Reference: **MAS Charter School / West Parent Loop and Parking (L16-D044)**
Traffic Circulation Layout Comment Responses

MAS School Parking Lot TCL Comment Response Log			
COA Hyd/Trns Ref #: L16D044		TCL Review Date: 5/11/23	
Department / Reviewer	Comment #	Comment	Response
COA Planning Dept Development Review Services / Marwa Al-najjar	1	The traffic circulation layout must be signed by an engineer or architect licensed in the state of New Mexico.	Noted, revision includes nm seal and signature.
	2	Identify all existing access easements and rights of way width dimensions	Right of way width dimensions added to plan sheets. Ex access easements on site called out. Previous access easement at NW corner of site is to be vacated under the approved Plat SD-2022-00002
	3	Driveway Accesses off Yale Blvd.: -Minimum accesses width should be 22-ft -Both accesses must be updated to the current ADA standard -Show on the site plan the required turned around before the gate (min. 20-ft set back).	Existing driveways to be reconstructed to provide ADA compliance through the driveway and curb ramps. Driveways are intended to be one-way only, with the northern driveway being entry only and the southe

SHEET NUMBER
TCL-01

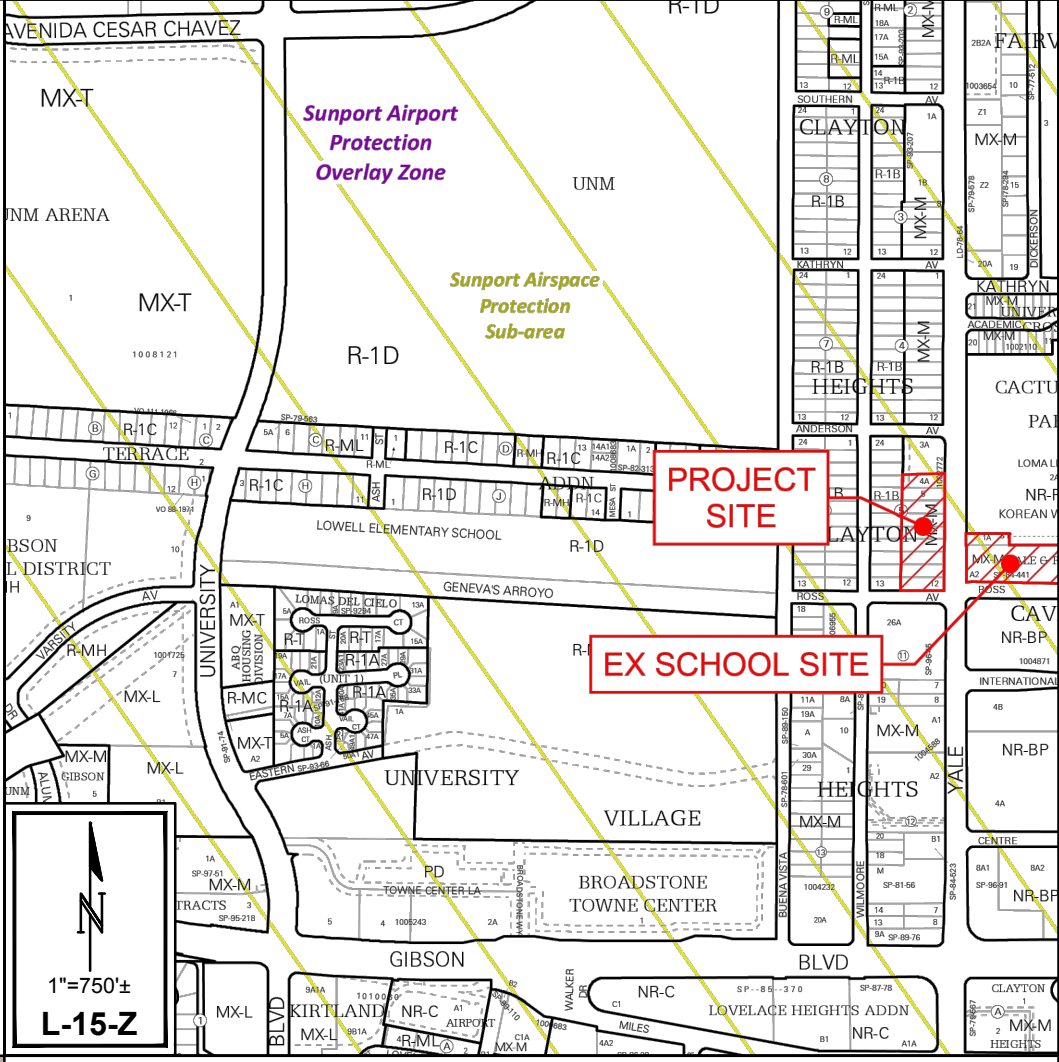
4	ADA curb ramp at the corner of Yale Blvd. and Ross Ave. must be updated to current standards and have truncated domes installed.	Existing x-slope along southwestern half of the ADA ramp at the NWC of the intersection was verified to be beyond ADA x-slope 2% maximum. Replacement of of southwestern portion of the ramp added to PWO plans and shown on sheet. Truncated domes added to plans. Existing ramp at the NEC of the intersection also verified to be beyond ADA maximum running & x-slope. Additionally, DRC comments asked for the ex crosswalk to be realigned to a straight alignment, meaning the ramp area will be widened to the north. Existing ramp to be reconstructed and detailed under PWO plans.
	5	The pavement marking "MC" should be shown in the opposite direction for motorcycles entering the parking space	"MC" pavement marking added to the motorcycle stalls.
	6	Per DPM, a 6 ft. wide ADA accessible pedestrian pathway is required from the ADA parking stall access aisles to the building entrances. Please clearly show this pathway and provide details.	Added ADA pathway to overall plan sheet noted pedestrian path from ADA stall to main school building on opposite side of Yale Blvd.

7	All one-way drives shall have "One Way" and "Do Not Enter" signage and pavement	Added signs and pavement markings at entry / exit drives
	8	The minimum drive through lane width is 12 feet with a 25-foot minimum radius (inside edge) for all turns. (A 15-foot radius can be used with an increase in lane width to 14 feet). Please dimension all lane widths and radii.	Revised queue lane to a min. 12-ft width throughout. Entry to queue lane revised to 14-ft width to maintain 15-ft internal radius. 14-ft width to taper down to 12-ft wide following internal radius PT.
	9	Clear sight triangle should start at the back of the sidewalk. Please revise the site plan.	Revised accordingly.
	10	Please specify the City Standard Drawing Number when applicable.	Added additional clarification to keyed notes referring to private items on site and noting to refer to Public work order #584685 for similar public items within public right of way and which City Std dwg applies to the public item.

COA Hyd/Trns Ref #: L16D044		TCL Review Date: 5/11/23	
Department / Reviewer	Comment #	Comment	Response
	11	Provide notes showing what work is included and on the work order and the private work on site.	Provided additional keynotes calling out work within the public right-of-way which will be shown on the PWO plan set. Also included City Project Number of the PWO in keynote labels.
	12	Please add a note on the plan stating "All improvements located in the Right of Way must be included on the work order."	Added note
	13	Unused curb cuts must be replaced with sidewalk and curb & gutter. A build note must be provided referring to the appropriate City Standard drawing.	Added note. There are no existing curb cuts along 1717 Yale Blvd SE frontage to public ROW.
	14	Add a note stating "All broken or cracked sidewalk must be replaced with sidewalk and curb & gutter." A build note must be provided referring to the appropriate City Standard drawing.	Added note
